Transportation Impact Assessment

PROPOSED GAS STATION DEVELOPMENT

8605 Campeau Drive, City of Ottawa

**Re: Transportation Impact Assessment - Addendum
Proposed Gas Station Development
8605 Campeau Drive, City of Ottawa
Our Project No. NT-20-091**

Drawing file: plan / All_Image Referencing_Zoning Bylaw Amendment Application_Image Reference_2022-10-03 - Site Plan - D02-02-22-0087.PDF

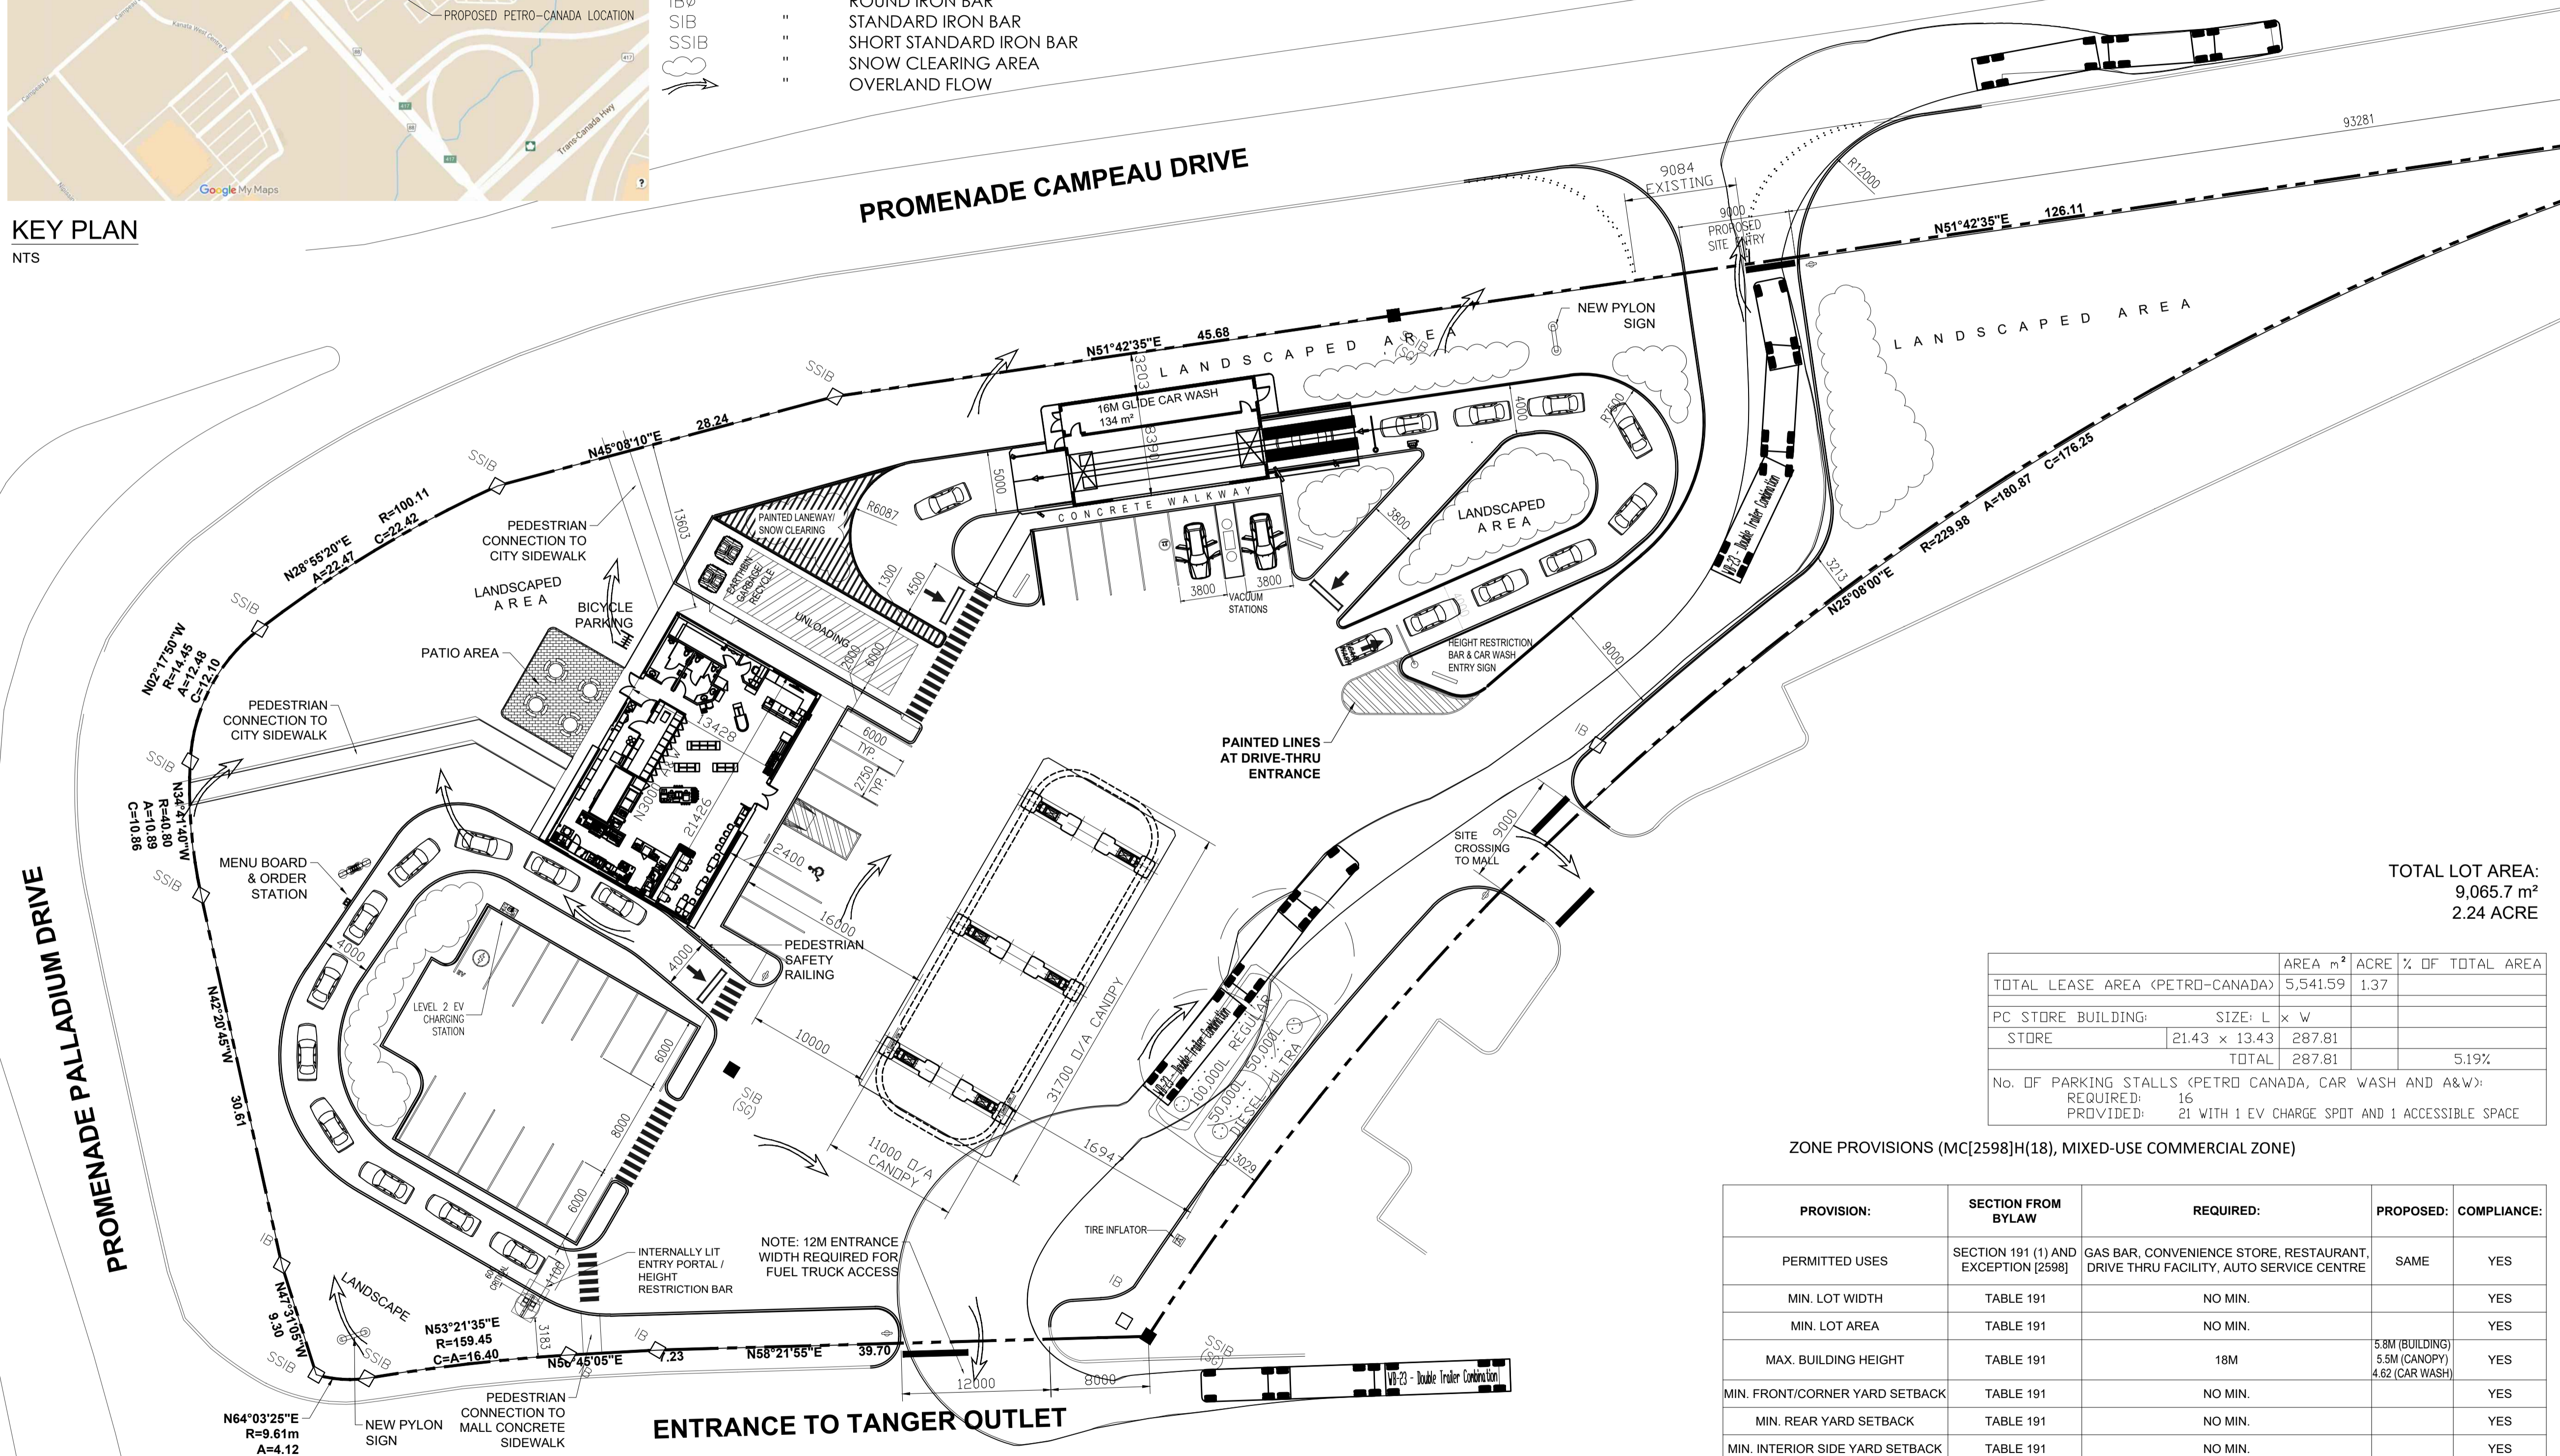
Indicate in the report if access widths meet bylaw requirements. Narrow access widths as much as possible to meet these requirements. Wider accesses must be justified with turning movement diagrams. The submitted diagrams do not provide this justification.

Confirm the location of the Campeau Drive access. There currently exists an entrance to this site that was is not constructed to current standards. If the proposed access is not in the location of the existing access the existing access must be removed. TWSI's should not be placed in the sidewalk at the access and curb returns

should be removed in front of the sidewalk and cycle track. A continuous sidewalk and cycle track with delineator strip is required and the preference is to have the sidewalk on a continuous elevation. Refer to City of Ottawa standard detail SC7.1. Pedestrians should not step down to the road level as they cross the access. Use the boulevard to shift from sidewalk elevation to street level. In addition, provide a green line across the access to highlight the cycle track. Motorists should be clear that priority is given to pedestrians and cyclists crossing the access.

Response: The vehicle turning diagram demonstrates that a 12.0 m driveway is required for fuel truck access.

Response: Acknowledged.
